# CITY OF ALBUQUE

**Re: Mesa del Sol Innovation Park Tracts A1A3, A1A4, A1A5 & A4A  
2001 Stieglitz Ave SE, Erosion and Sediment Control Plan  
Engineer's Stamp Date 12/4/2021 (R16E100)**

Based upon the information provided in your submittal received 2/19/2021, the above referenced ESC Plan can't be approved until the following comments are addressed.

BOBBY FOSTER ROAD & UNIVERSITY BLVD
IMPROVEMENTS, PH. I
TEMPORARY SEDIMENT AND EROSION CONTROL DRAWINGS
ALBUQUERQUE, BERNALILLO COUNTY, NM

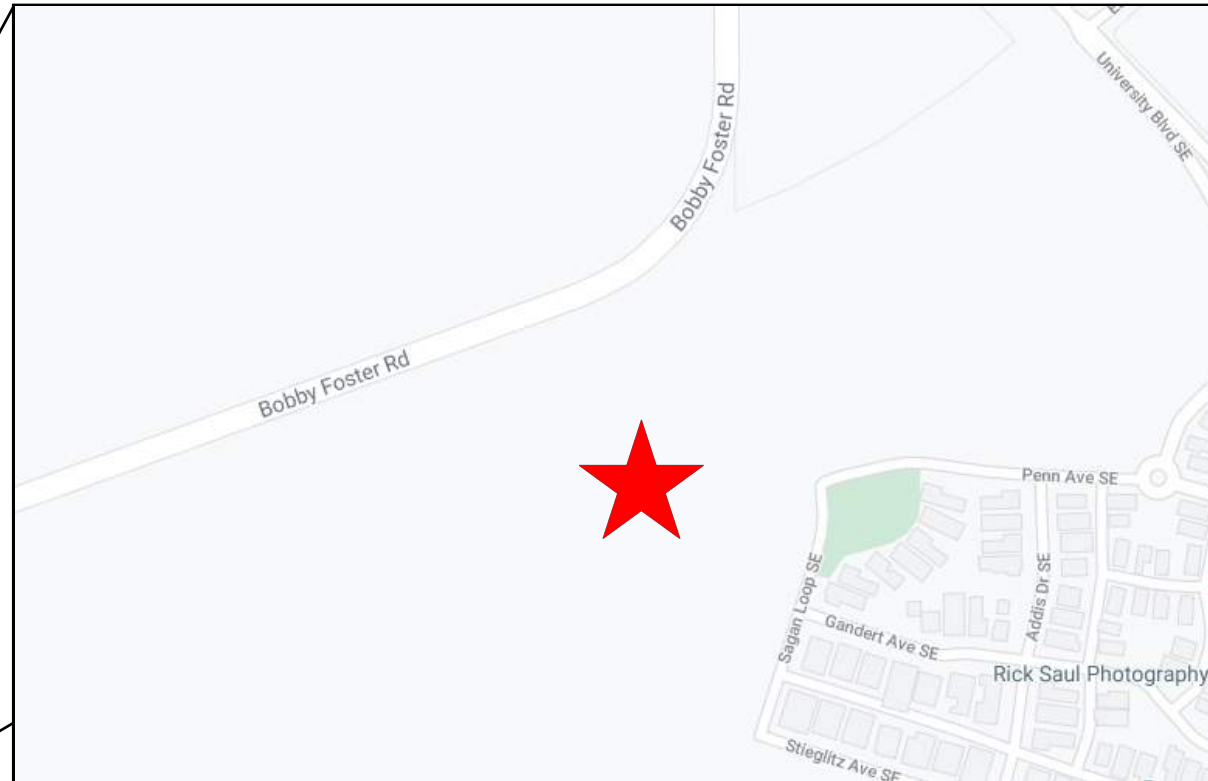
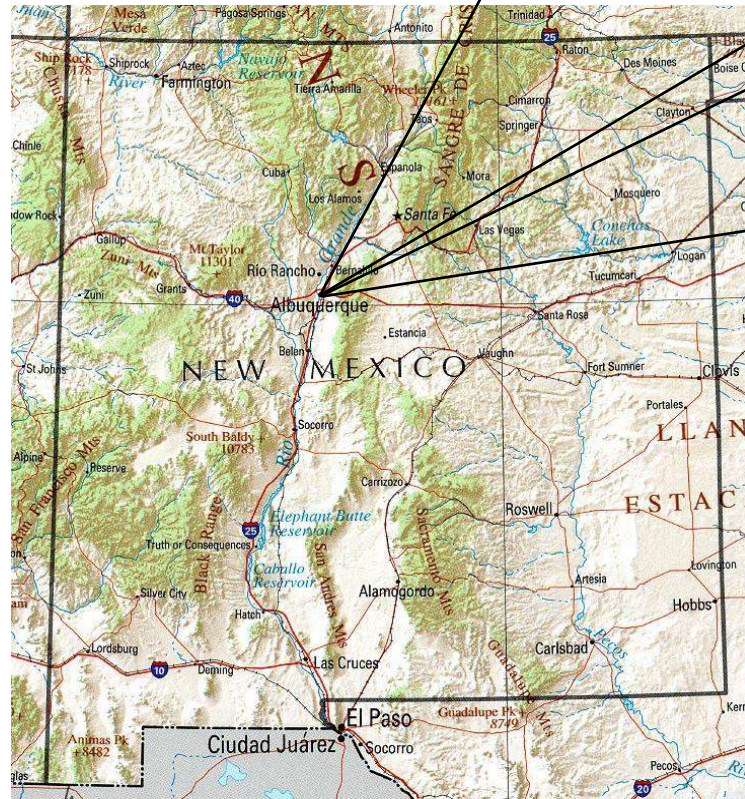
3. The finished grades must be shown on the ESC Plan, and they must agree with the approved Grading Plan. The stockpile areas and limits of Stieglitz paving don't match the approved plan.

4. Revise the limits of disturbance to include all areas of Earth-Disturbing and Construction Support Activities. Add the disturbed area south of the pond. Revise the map as necessary during construction to keep it up to date. Identify the limits of the International School site that is being controlled by a separate operator under NMR1003KQ, The Rachel Mathew Family of Companies. Which operator is responsible for the sidewalk and stabilization between the sidewalk and the street?

5. Add silt fence around the site's outside perimeter to comply with the Fugitive Dust Permit and CGP 2.2.3. For areas where perimeter controls are not feasible, include documentation to support this determination and show the other practices that will be implemented to minimize discharges of pollutants in stormwater associated with construction activities.

6. Identify the native cover and expected minimum cover for final stabilization.
7. Show additional areas of vegetative stabilization next to roads where applicable. Include all areas of earth-disturbing activities that are not otherwise stabilized with pavement or sidewalks. Paving limits are inaccurate. A strip of vegetative stabilization is missing next to the roads.

EROSION CONTROL PLAN

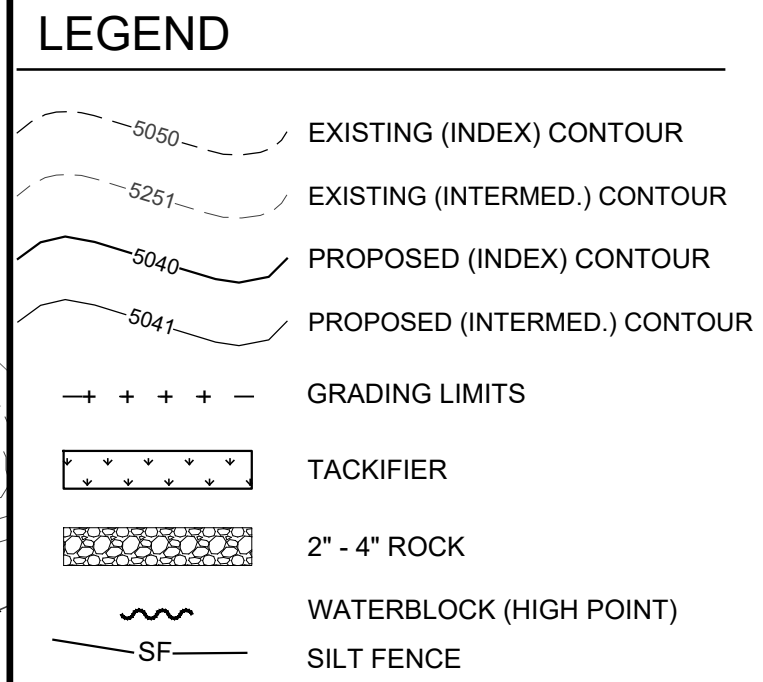
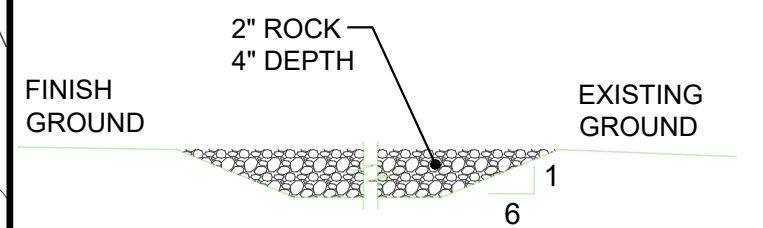
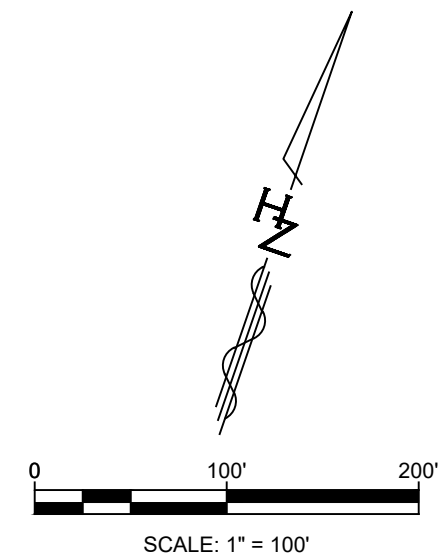
9. Please add a description of the word “Tacifier” as it appears under the two stockpile labels on sheet 7.
10. Please revised ESC Plan and resubmit along with the information sheet and re-review fee. Please remember to update the engineer’s stamp.
